BUILDING CODE OF AUSTRALIA COMPLIANCE ASSESSMENT REPORT FOR DA SUBMISSION

MIXED USE DEVELOPMENT COMPRISING OF 4 BUILDINGS

93-107 CECIL AVENUE AND 9-10 ROGER AVENUE, CASTLE HILL

REPORT NO. ► 13685 Rev. 01

Drawing Title
BUILDING B - LEVEL 20

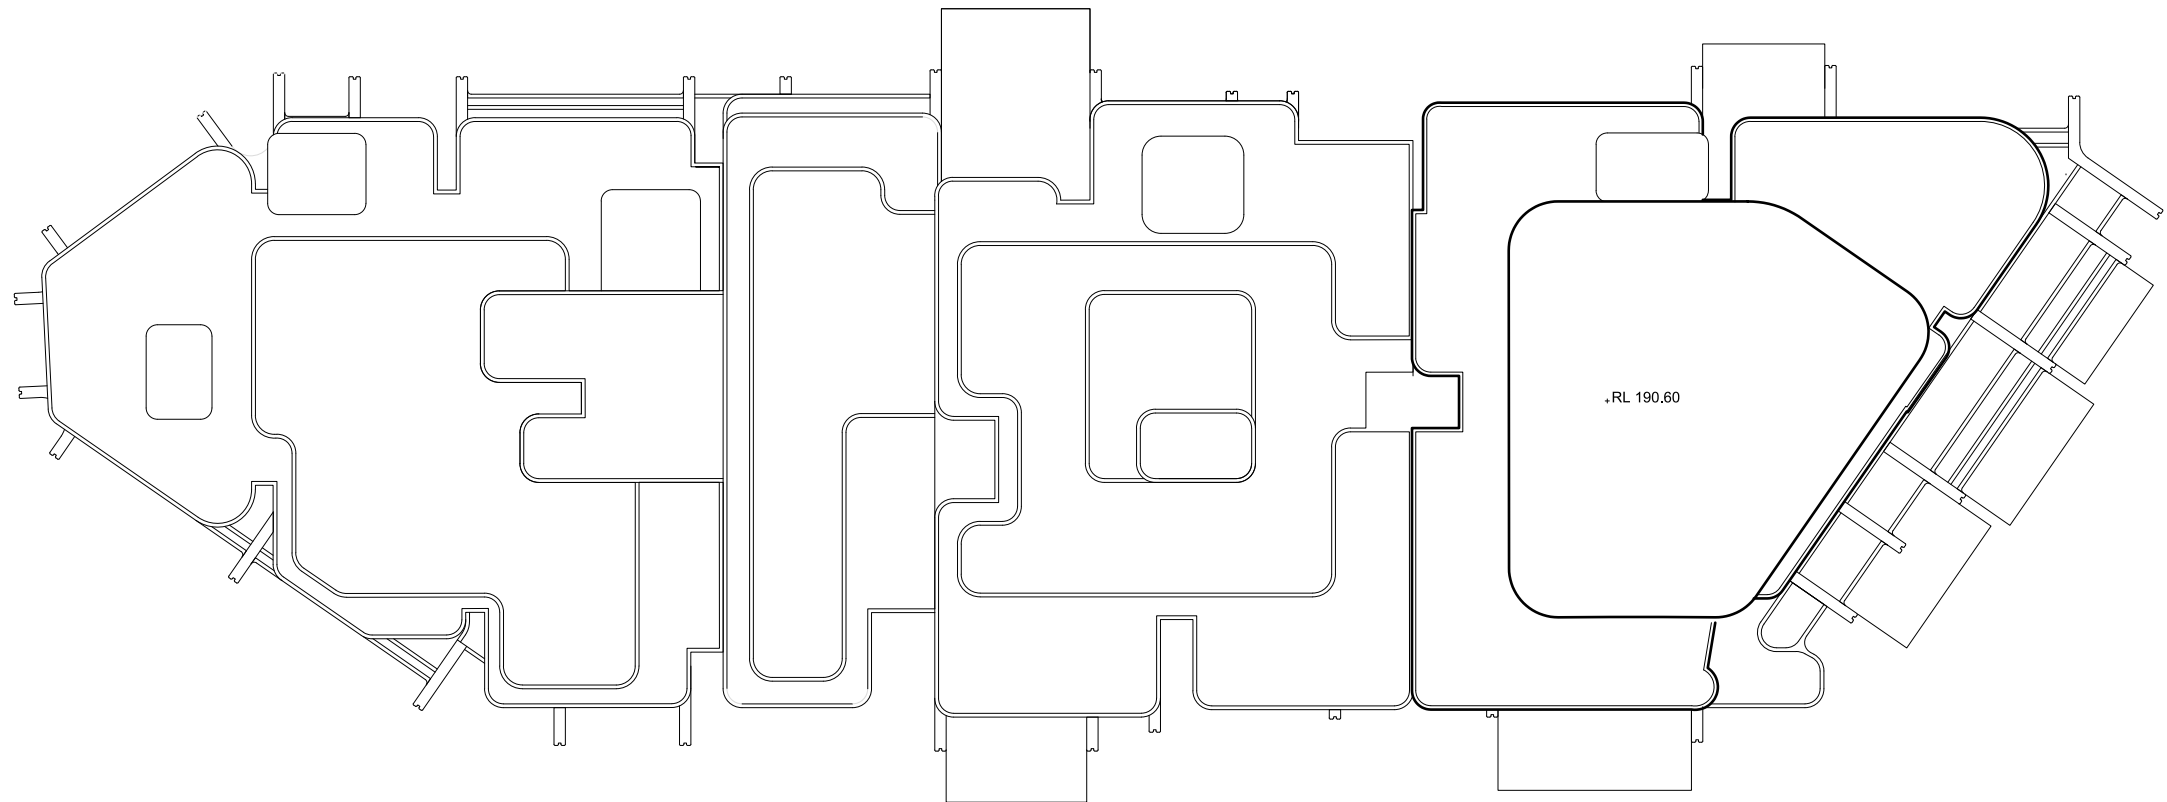
BCA Clause	Deemed-to-Satisfy Provision to be addressed
	<p>Level 20:</p> <ul style="list-style-type: none"> • <u>Building B (Northern fire stairways):</u> Distance between alternative exits is less than 9m (circa 7.7m). • <u>Building C (Northern fire stairways):</u> Distance between alternative exits is less than 9m (circa 7.7m). <p>Level 21-26:</p> <ul style="list-style-type: none"> • <u>Building C (Northern fire stairways):</u> Distance between alternative exits is less than 9m (circa 7.7m). <p>DTS Non-compliance:</p> <p>All scissor stairways are alternative paths of travel that converge such that they become less than 6m apart from each other. This will need to be addressed via a performance-based solution.</p>
<p>NSW D2D8</p> <p>Width of exits and paths of travel to exits</p> <p>[2019: D1.6(b), (c), (d) and (e)]</p>	<p>Further information required:</p> <p>Level 2: The commercial space to the northern side of building C has been assessed as a class 5 and has a floor area of approximately 304m². In accordance with D2D18, it can accommodate a maximum of 31 persons and therefore the aggregate width of exits must be no less than 1m. As there are no exit doorways detailed, it is unclear if the widths of the exit/s comply.</p>

Drawing Title
BUILDING C - LEVEL 1

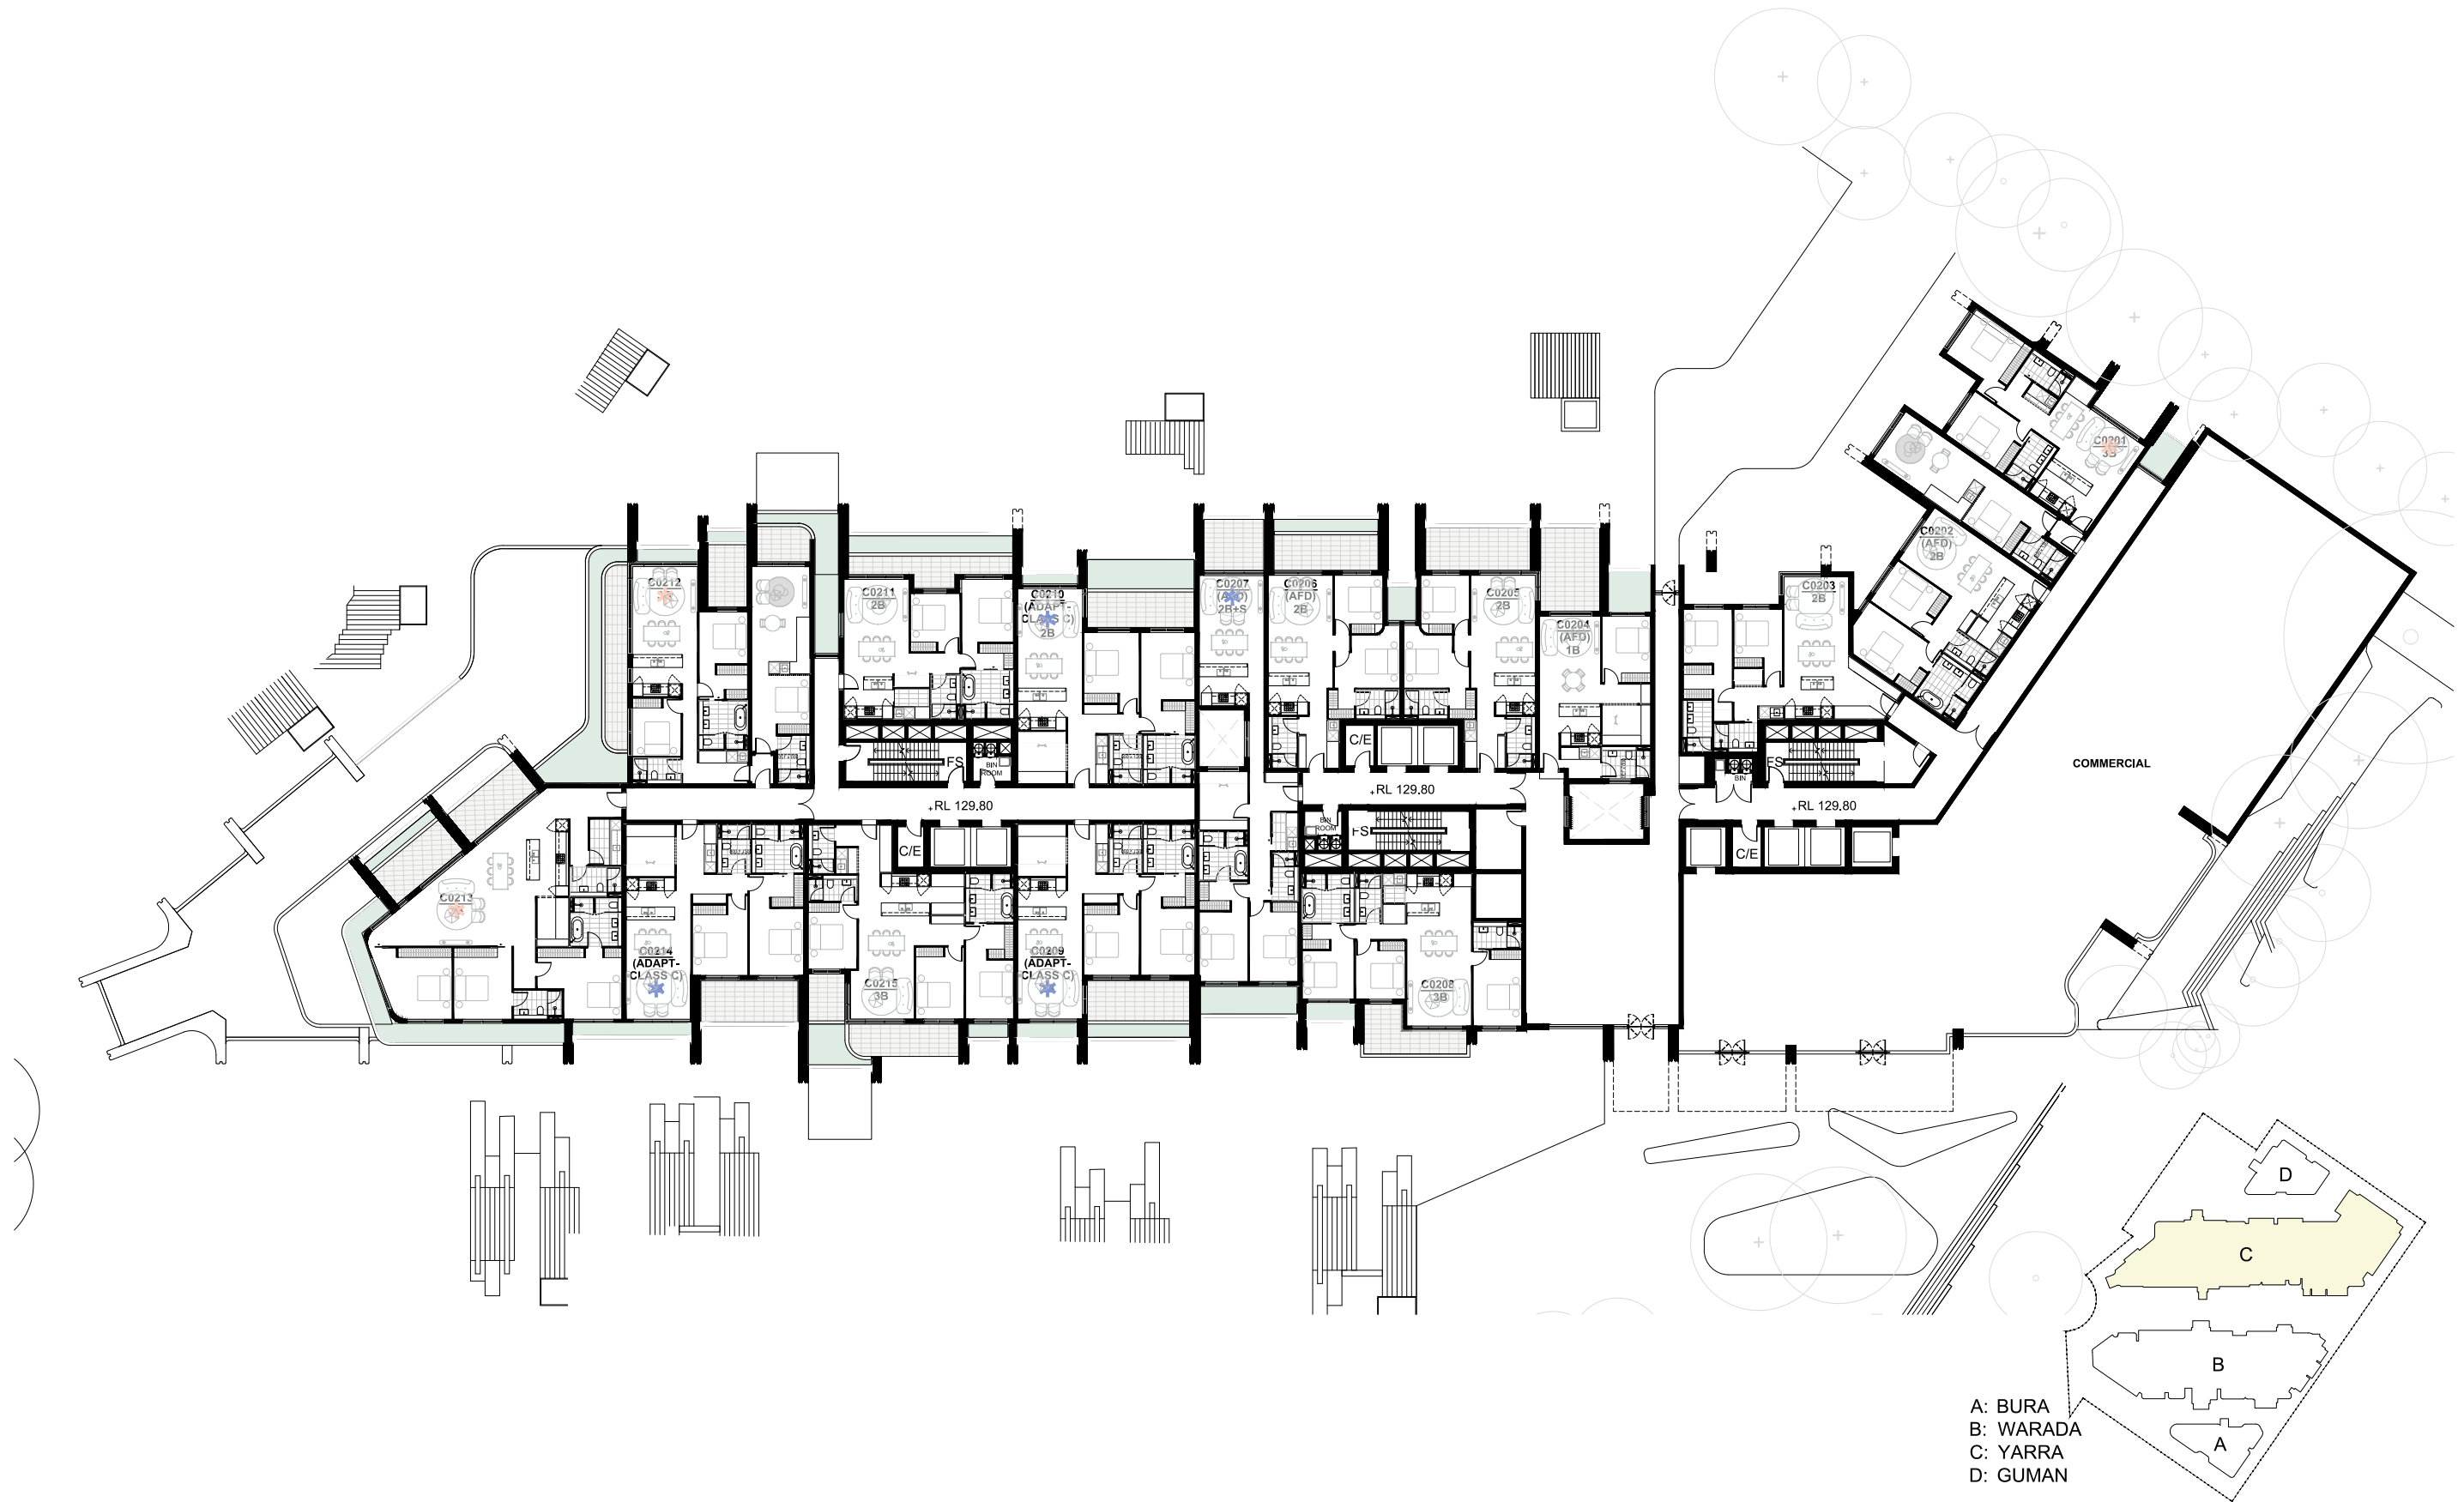
Level 1: More than 20m from an exit or a point of choice (worst case circa 24.8m) and more than 20m from an exit or a point of choice for an area not within a SOU (worst case circa 24.9m).

Drawing Title
BUILDING C - LEVEL 10

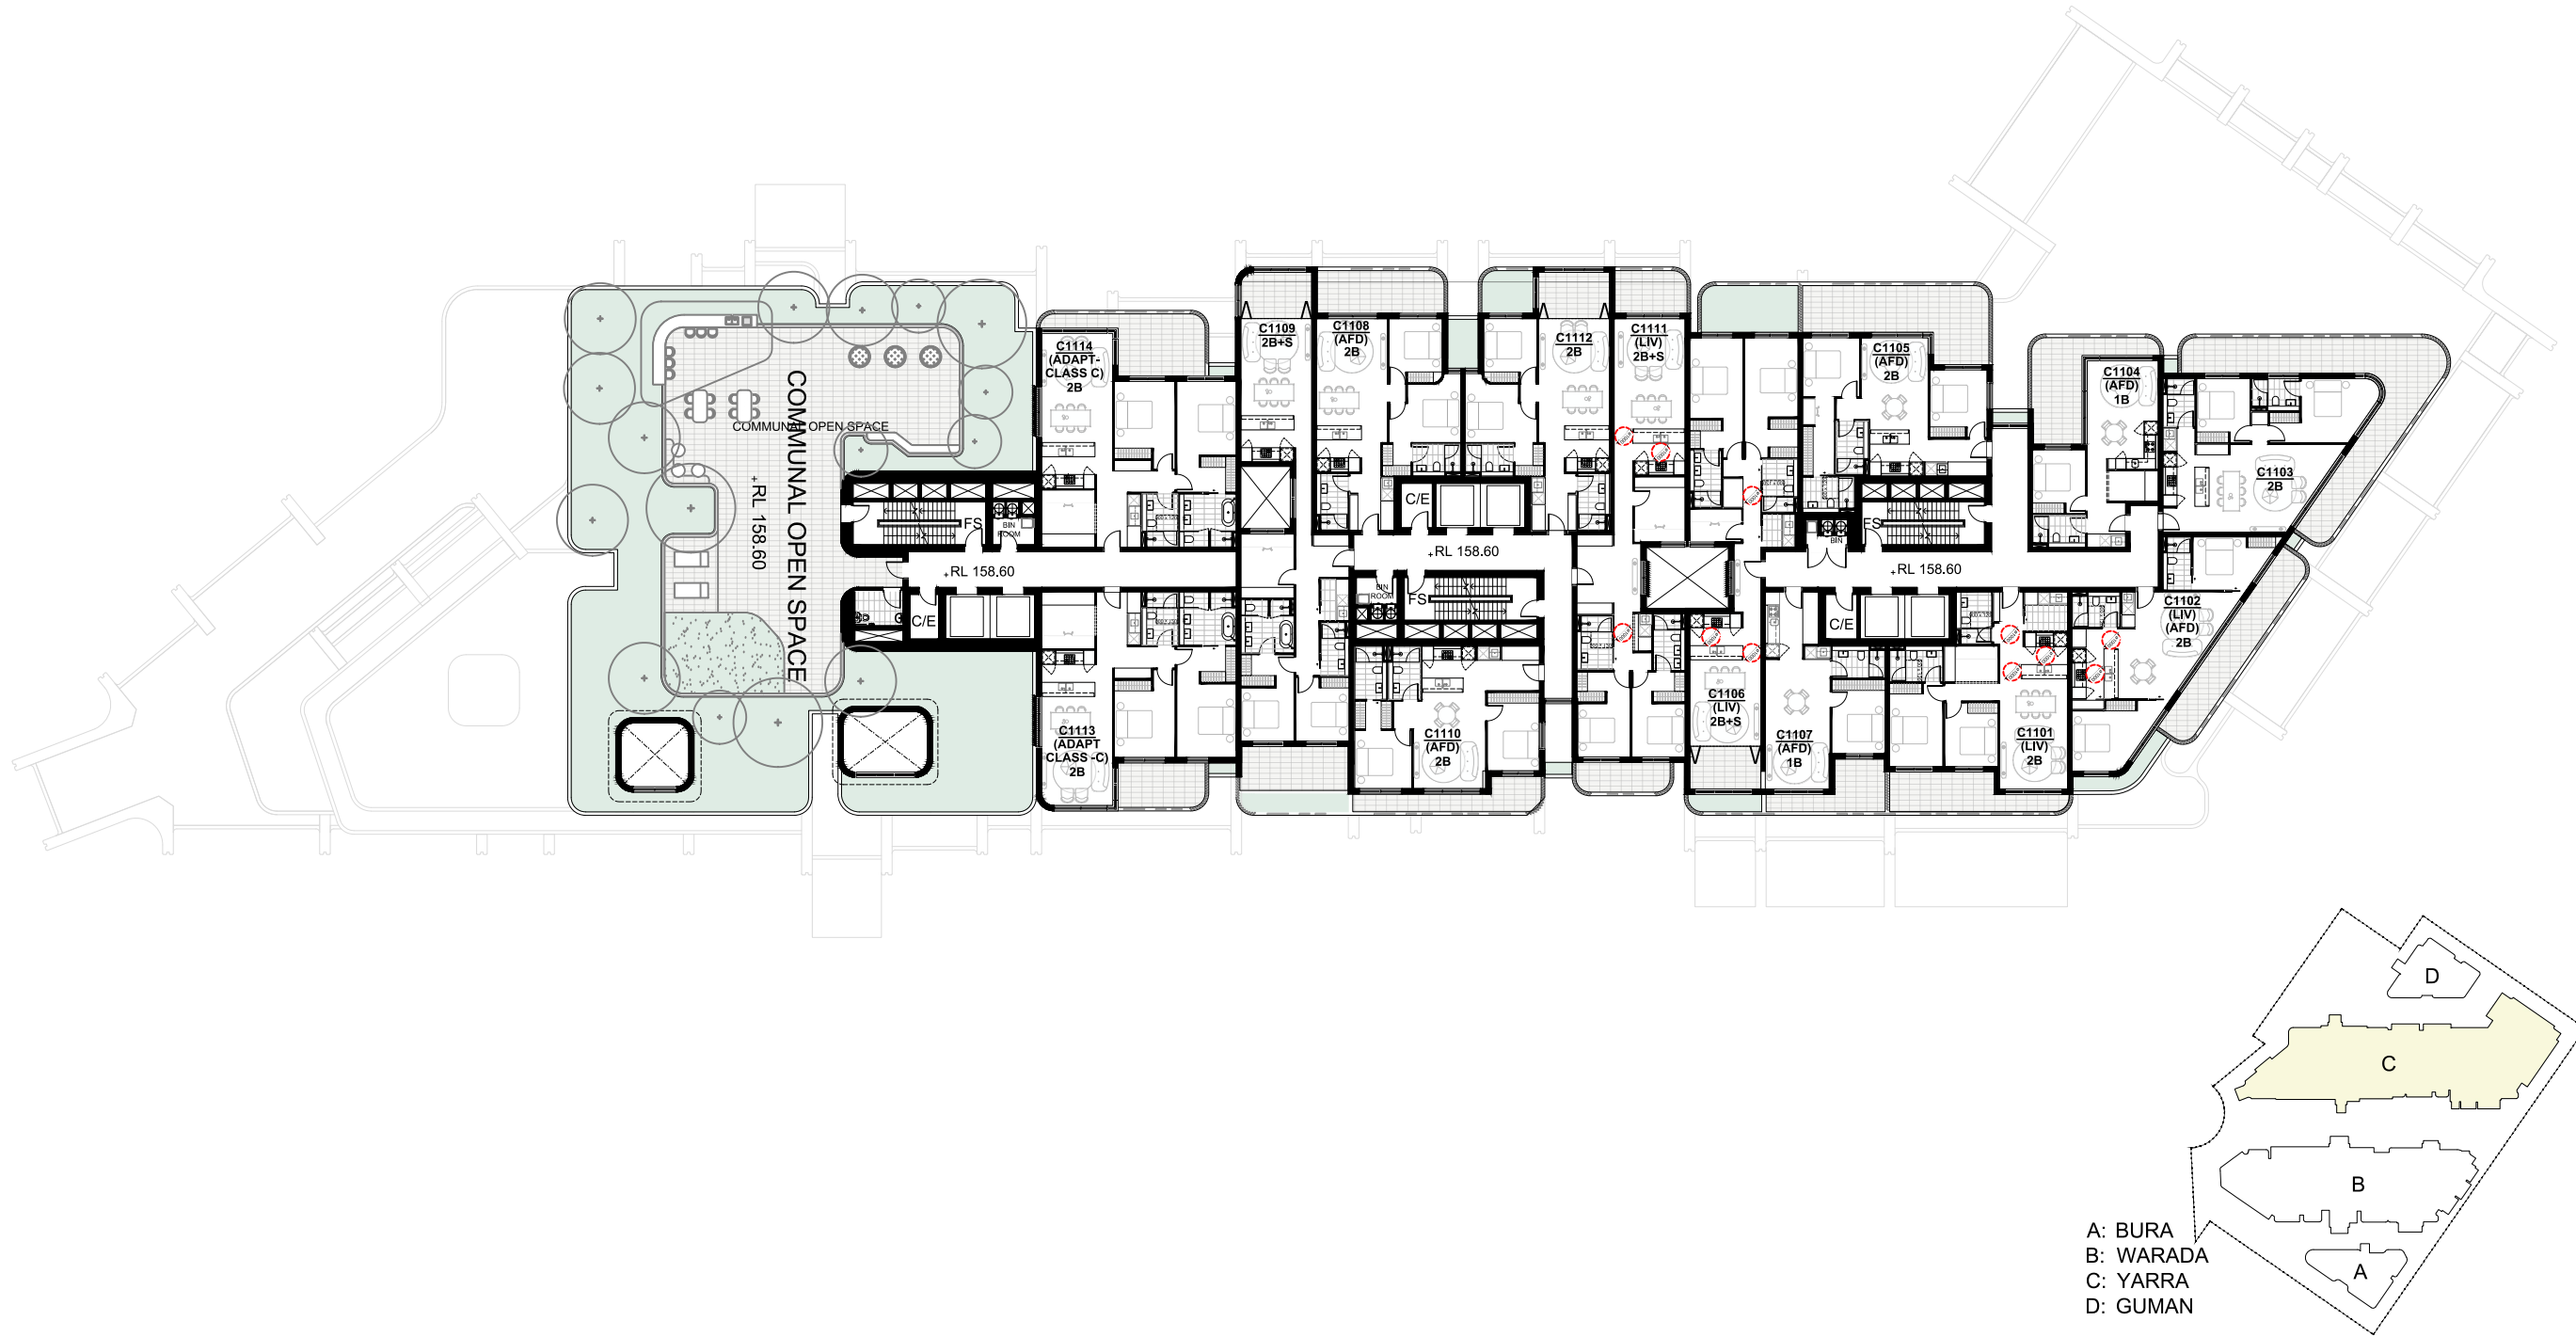
BCA Clause	Deemed-to-Satisfy Provision to be addressed
	<p><u>Level 10:</u></p> <ul style="list-style-type: none">• <u>Building B (Northern fire stairways):</u> Distance between alternative exits is less than 9m (circa 7.7m).• <u>Building B (Middle fire stairways):</u> Distance between alternative exits is less than 9m (circa 8.3m).• <u>Building B (Southern fire stairways):</u> Distance between alternative exits is less than 9m (circa 8.4m).• <u>Building C (Northern fire stairways):</u> Distance between alternative exits is less than 9m (circa 7.7m).• <u>Building C (Middle fire stairways):</u> Distance between alternative exits is less than 9m (circa 8.3m).• <u>Building C (Southern fire stairways):</u> Distance between alternative exits is less than 9m (circa 8.3m). <p><u>Level 11:</u></p> <ul style="list-style-type: none">• <u>Building B (Northern fire stairways):</u> Distance between alternative exits is less than 9m (circa 7.7m).• <u>Building B (Middle fire stairways):</u> Distance between alternative exits is less than 9m (circa 8.3m).• <u>Building C (Northern fire stairways):</u> Distance between alternative exits is less than 9m (circa 7.7m).• <u>Building C (Middle fire stairways):</u> Distance between alternative exits is less than 9m (circa 8.3m).• <u>Building C (Southern fire stairways):</u> Distance between alternative exits is less than 9m (circa 8.5m). <p><u>Level 12 to 15:</u></p> <ul style="list-style-type: none">• <u>Building B (Northern fire stairways):</u> Distance between alternative exits is less than 9m (circa 7.7m).• <u>Building B (Middle fire stairways):</u> Distance between alternative exits is less than 9m (circa 8.3m).• <u>Building C (Northern fire stairways):</u> Distance between alternative exits is less than 9m (circa 7.8m).• <u>Building C (Middle fire stairways):</u> Distance between alternative exits is less than 9m (circa 8.3m). <p><u>Level 16 to 18:</u></p> <ul style="list-style-type: none">• <u>Building B (Northern fire stairways):</u> Distance between alternative exits is less than 9m (circa 7.7m).• <u>Building C (Northern fire stairways):</u> Distance between alternative exits is less than 9m (circa 7.7m).• <u>Building C (Middle fire stairways):</u> Distance between alternative exits is less than 9m (circa 8.3m).• <p><u>Level 19:</u></p> <ul style="list-style-type: none">• <u>Building B (Northern fire stairways):</u> Distance between alternative exits is less than 9m (circa 7.7m).• <u>Building C (Northern fire stairways):</u> Distance between alternative exits is less than 9m (circa 7.7m).• <u>Building C (Middle fire stairways):</u> Distance between alternative exits is less than 9m (circa 8.7m).
